M5 Junction 10 Improvements Scheme

Application by Gloucestershire County Council for an order granting Development Consent for the M5 Junction 10 Improvements Scheme

Advice following issue of decision to accept the application for examination – Planning Act (2008) as amended - Section 51

Original Size: A1    Scale: AS SHOWN    Project Ref. No.: 5197035    Sheet: 7 of 16    Rev: C01

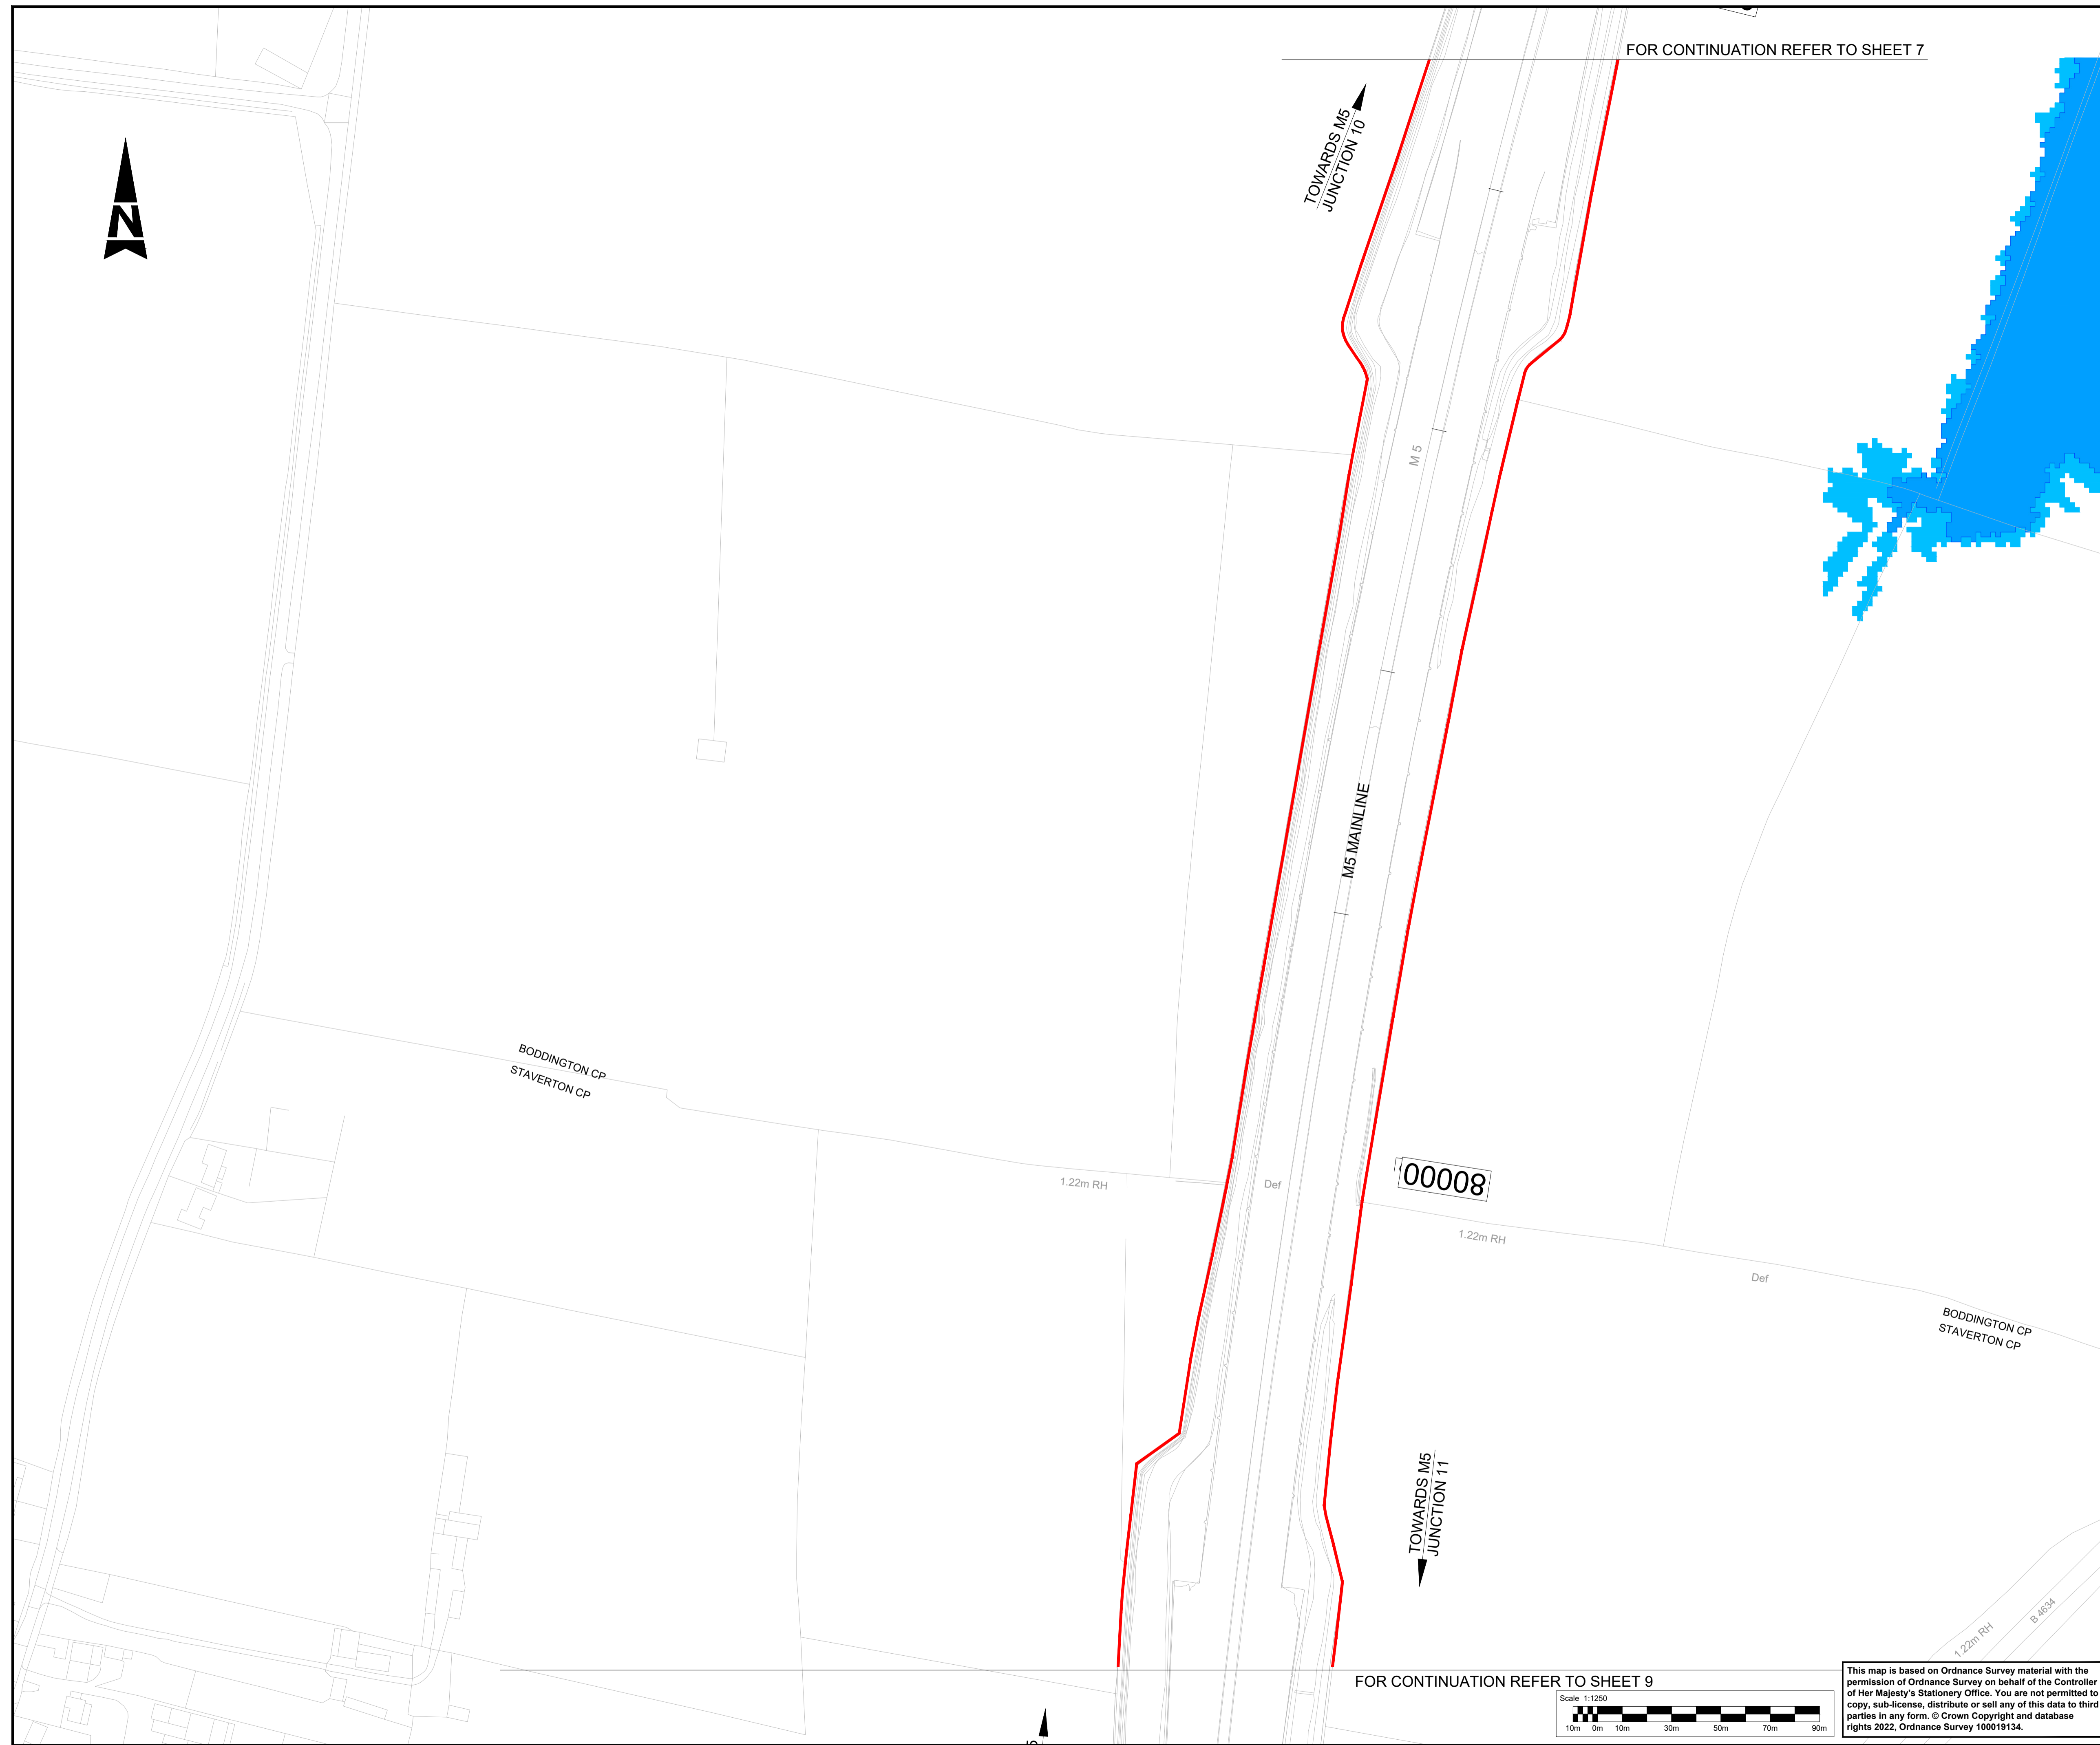
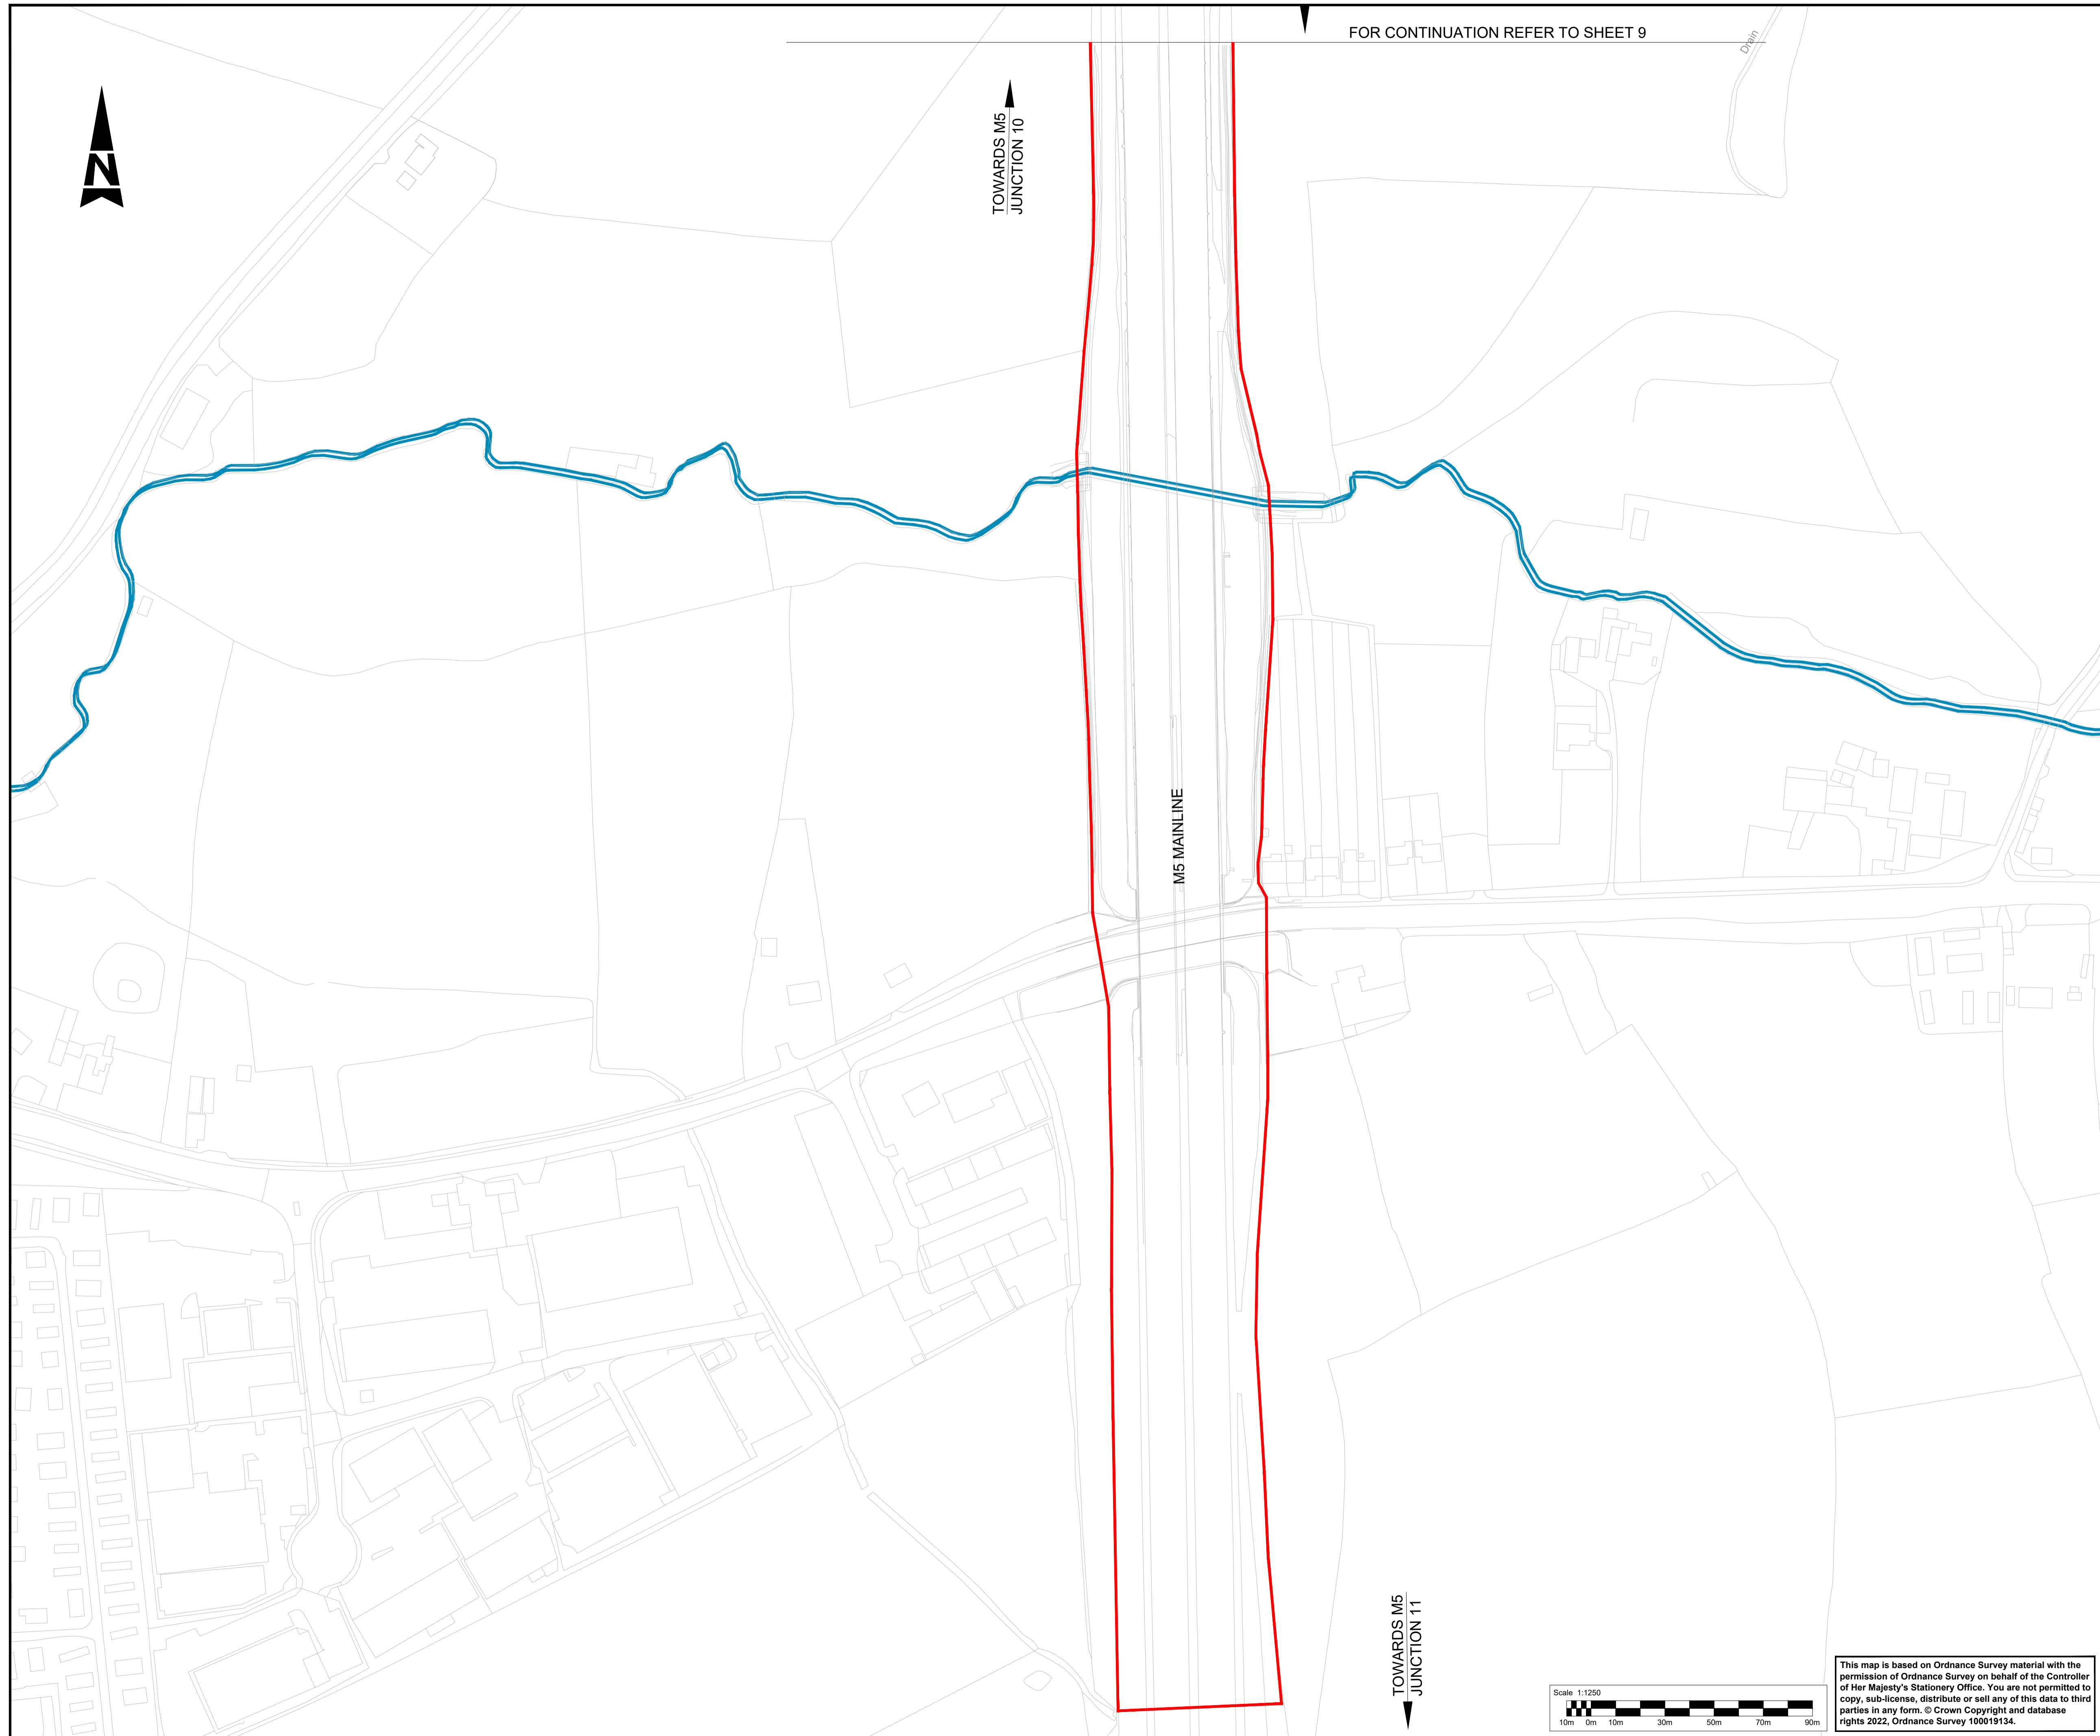
PINS comment: The exported large scale plan has some rendering issues, where the (former) Area of Outstanding Natural Beauty (now known as National Landscape) layer has sporadic horizontal lines that are not shown in the legend. The Applicant is also advised to update the terminology used.

There is also no base map to indicate the geographical location of the identified sites/features.

Applicant response: The Biodiversity Sites and Features Plan (Application document TR010063/APP/2.11) has been updated and changes made to the rendering of the green shaded area, and to the labelling of the Landscape area. The Cotswolds AONB has been amended to Cotswolds National Landscape.

A base map has also been included.
